**CHERWELL DISTRICT COUNCIL TOWN
AND COUNTRY PLANNING ACT 1990**

Appeal made by Mr Chadwick on the behalf of Mr Roger Yates against Cherwell District Council's refusal to grant a prior notification for the Prior Approval Notification under Class Q (b) for development referred to in paragraph (a) of Class Q for the change of use of a building and any land within its curtilage from a use as an agricultural building to a use falling within Class C3 (dwellinghouses) together with building operations reasonably necessary to convert the building referred to in paragraph (a) to a use falling within Class C3 (dwellinghouses) (Council's Ref. 23/01339/Q56) APP/C3105/W/22/3306638

**Figure 4 – Proposed Conversion – Elevations**

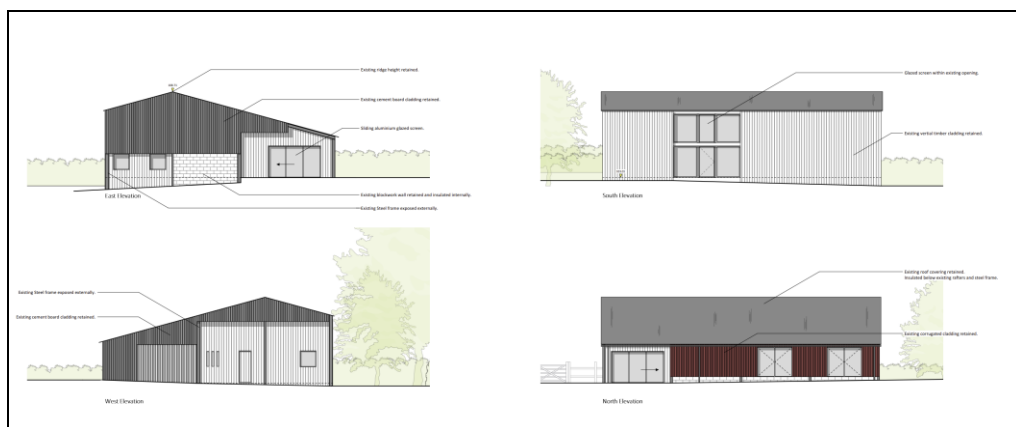
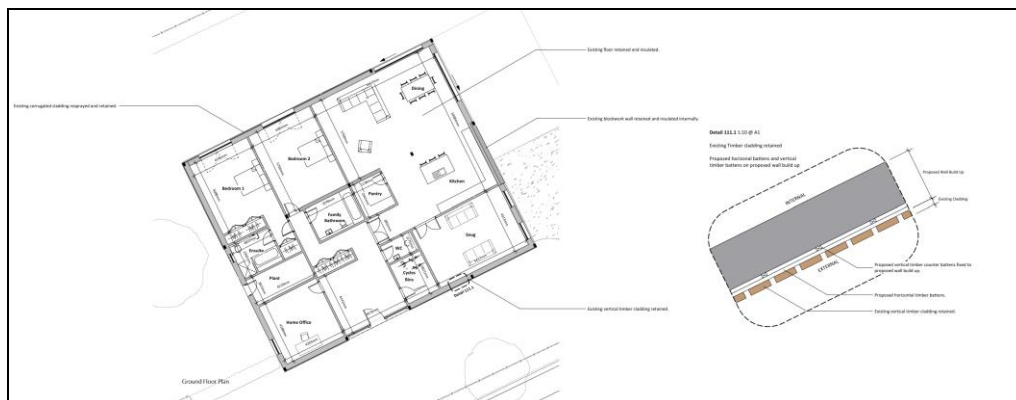
- 2.6. Paragraphs 4.2 and 5.15, and 5.32 of the Appellant's statement note the changes made from the previous appeal, (reference (APP/C3105/W/22/3306638) which was dismissed. This list includes "Incorporation of cladding and insulation inside the timber boarding". While insulation of the building may be permissible, the Council submits that the internal cladding of the building goes beyond what may be construable as a conversion of the existing building. As set out in the officer report, e.g. at paragraph 8.19, the Council submits that the proposal would result in a new structure within the barn rather than a conversion of the existing structure and that the proposed works do not rely on the existing structure alone.

- 2.8. In relation to paragraph 5.11 of the Appellant's statement, the Council submits that the proposed works go beyond what can be classed as insulating the structure and would result in a significant level of alteration and rebuilding work through the creation of a new internal structure. This goes beyond what can be classed as a conversion. If new internal structures were permissible under Class

Q applications, this would allow for most agricultural buildings which otherwise could not be converted to be converted. A new internal structure would represent a fresh build and would include operations that would go beyond those reasonably necessary for the conversion of the building.
